Our Ref: WA/106/20/DOC

Approval of details reserved by condition imposed under ref WA/22/15/OUT relating to Condition Nos 6 - materials & finishes, 10 - hard & soft landscaping, 11(a) - protection of retained trees, 12 - surface water drainage, 14 - maintenance & managements of SuDs, 15 - foul drainage and 20(d) - forecourt layout, drainage, position & intensity of lighting fitments.

Arun District Council have decided to **REFUSE details reserved by condition for the following reasons:**
Insufficient information has been submitted to demonstrate that the site will be satisfactorily drained.

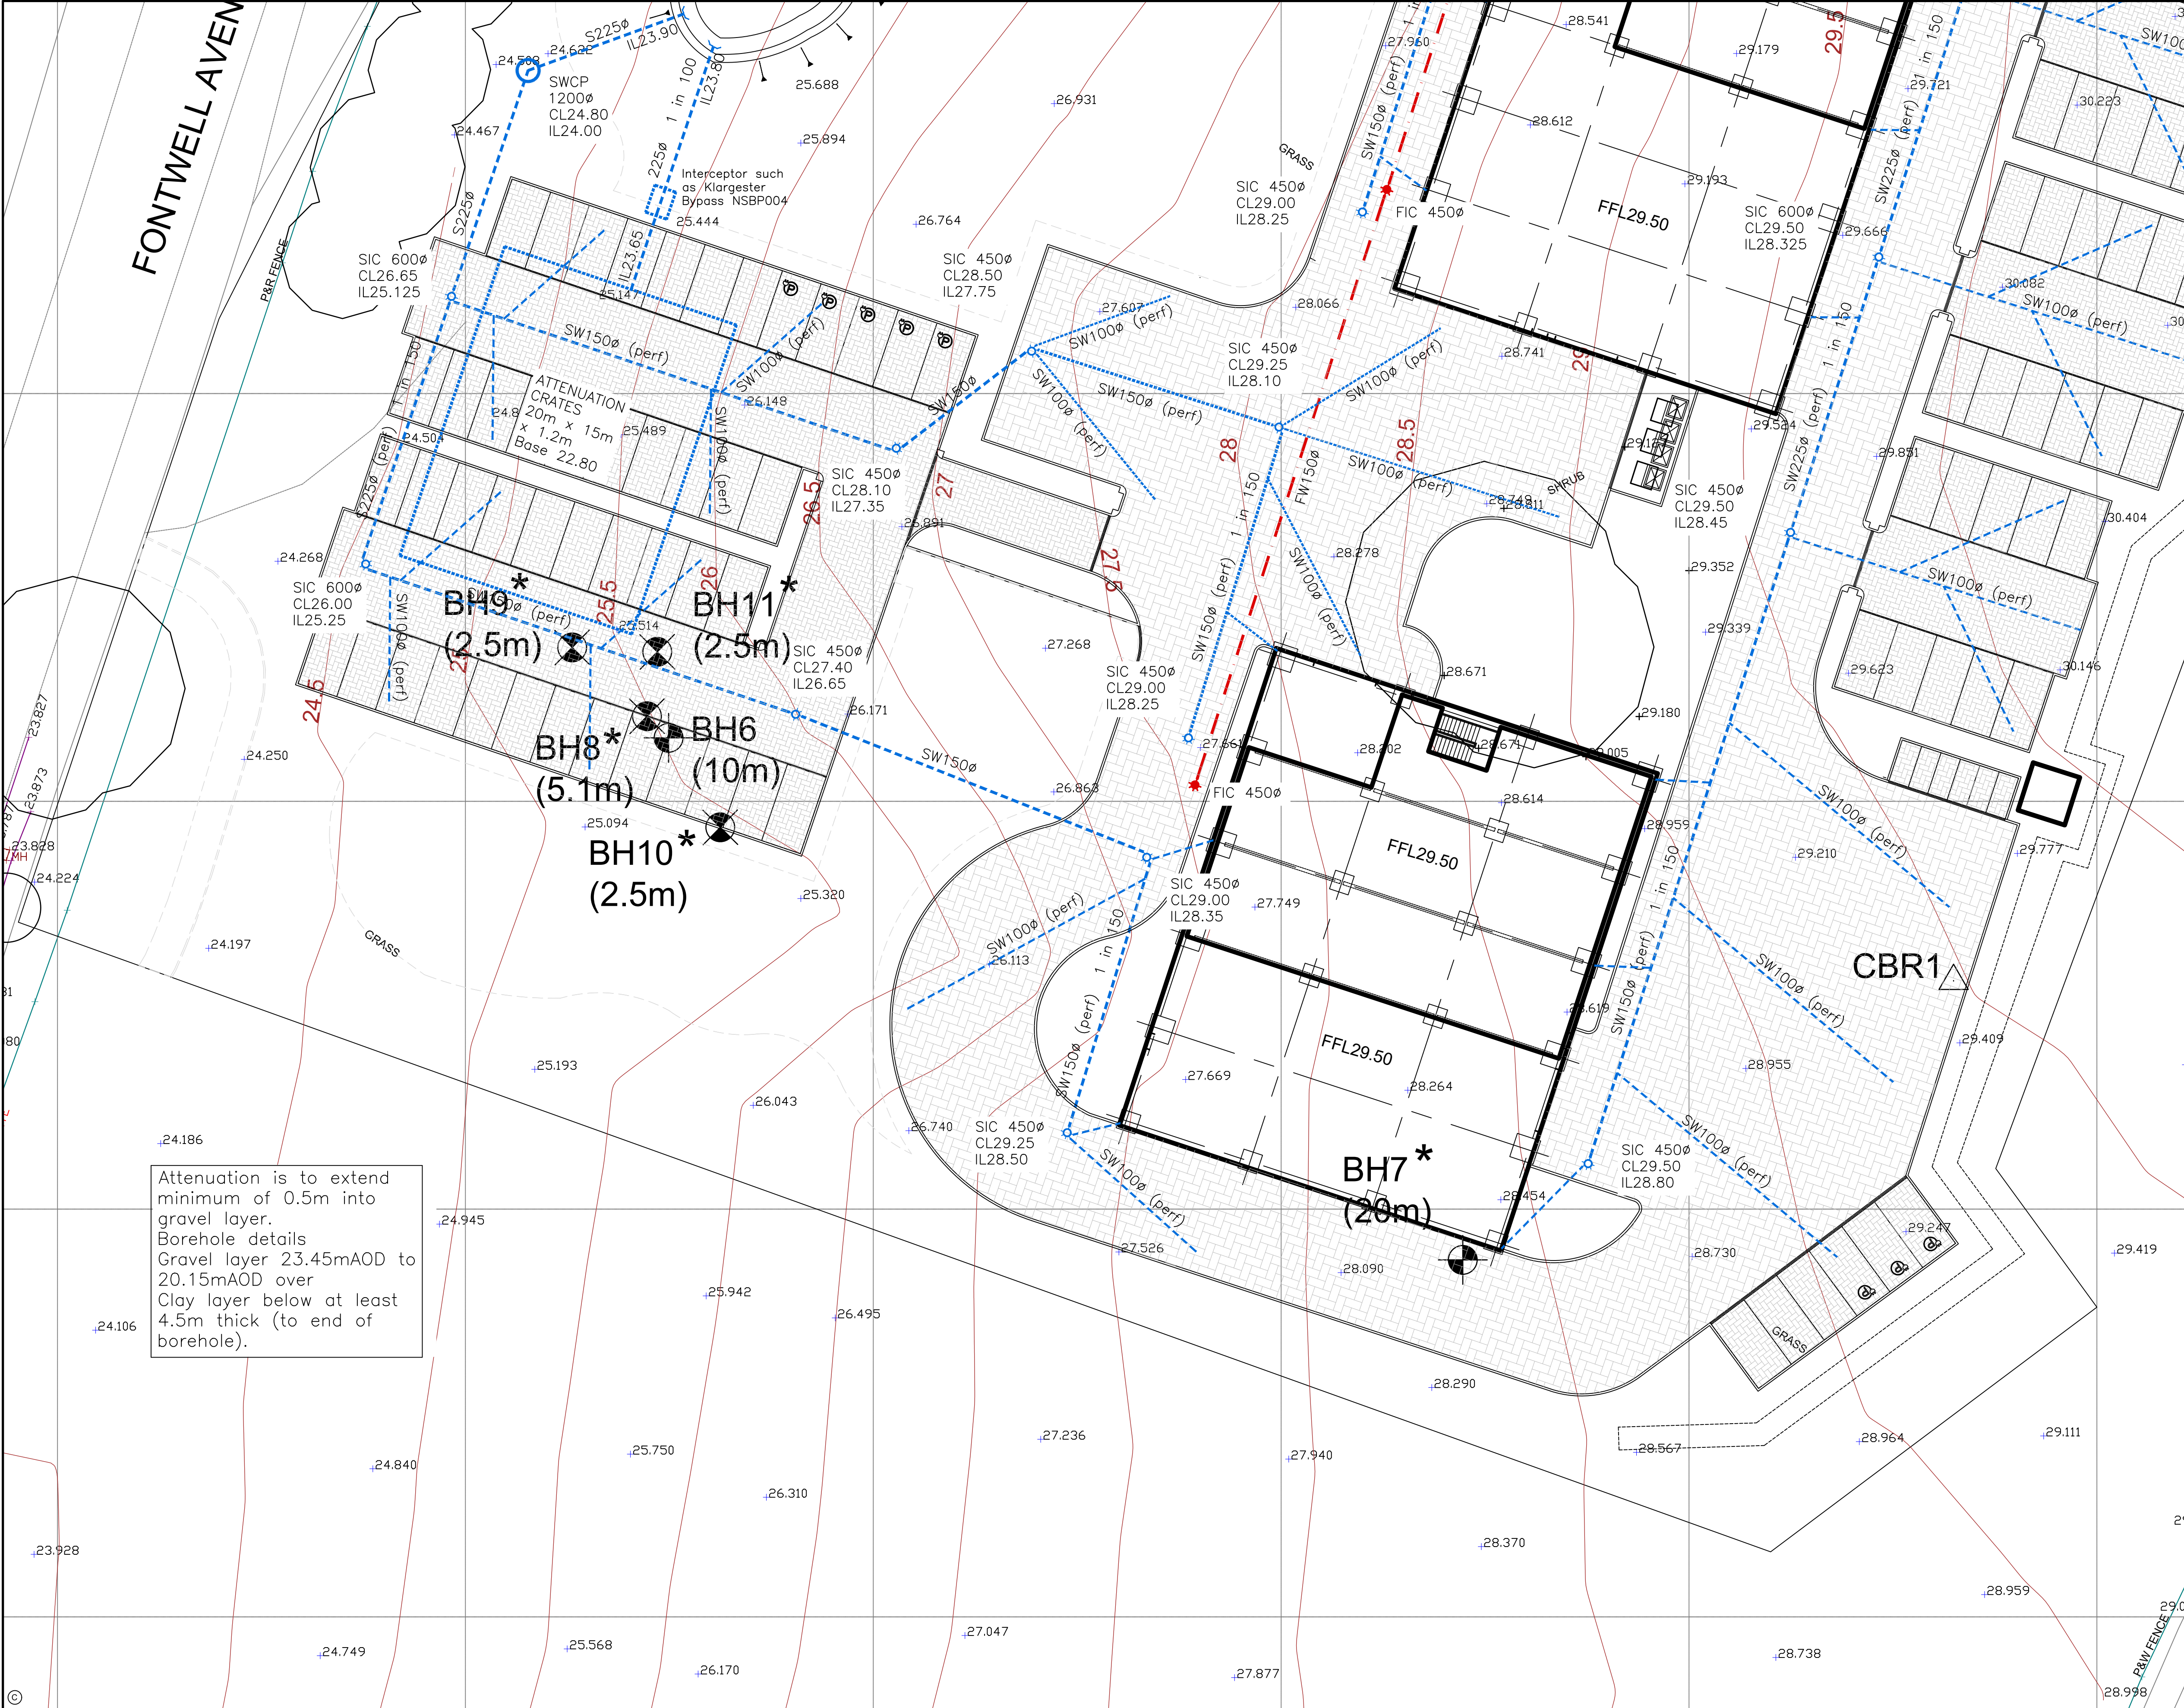
A detailed drainage strategy for the light industrial area is required, including details of the type of

drainage basin (attenuation or infiltration), details of the SW connections, SW outfalls (discharge points) and the level of water quality treatment must be suitable for the land use (B1 (b)/(c)) with reference to the CIRIA SuDS Manual.
